**Subject:** RE: FAO James Evans re planning application no. 2026/62/91894/W

I am a local resident writing to formally alert you to significant, material inaccuracies in the submitted plans for application 2026/62/91894/W at 7 Little Croft Close Holmfirth HD92BD

SECOND FLOOR PLAN_
AS EXISTING
Scale 1.50

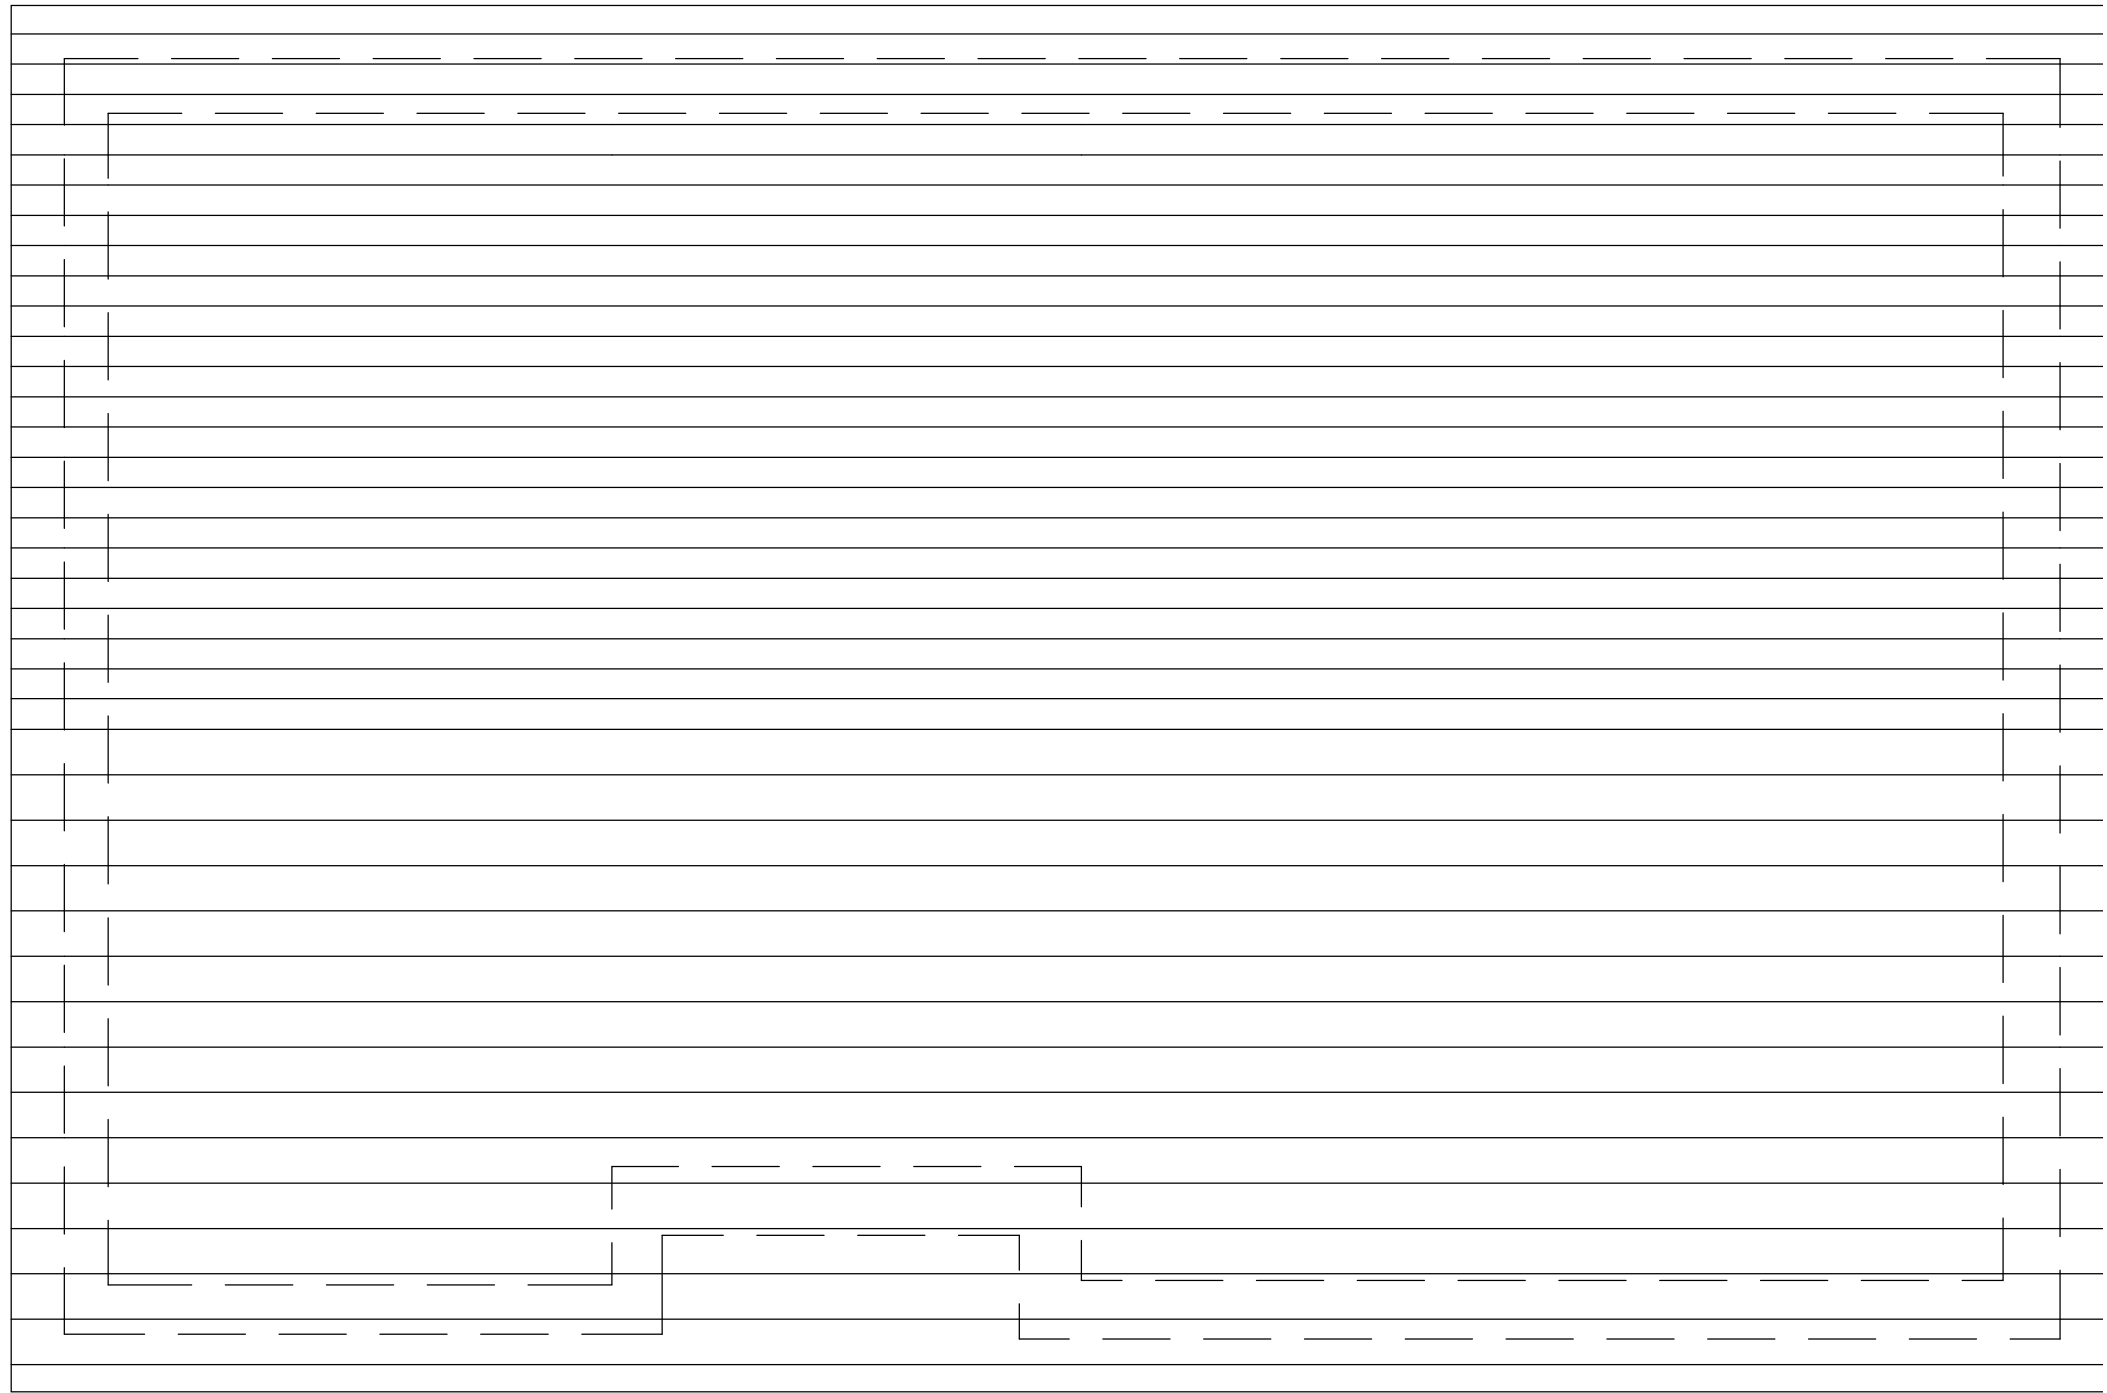
The existing site plans and elevation drawings submitted by the applicant are fundamentally incorrect. They completely omit an existing loft conversion on the property, which contains two additional bedrooms and roof windows which has been carried out since the original property was completed in July 2025 in what would appear to be a breach of the original planning consent for the development.

2. **Parking requirements:** The baseline bedroom count is incorrect as the property is now a seven bedroom property understating local parking impact and traffic flow.

Thank you for your email, I will get in touch with the agent to clarify the situation with the loft conversion. If they confirm this is already in place the application description will have to be changed and new plans will have to be submitted.
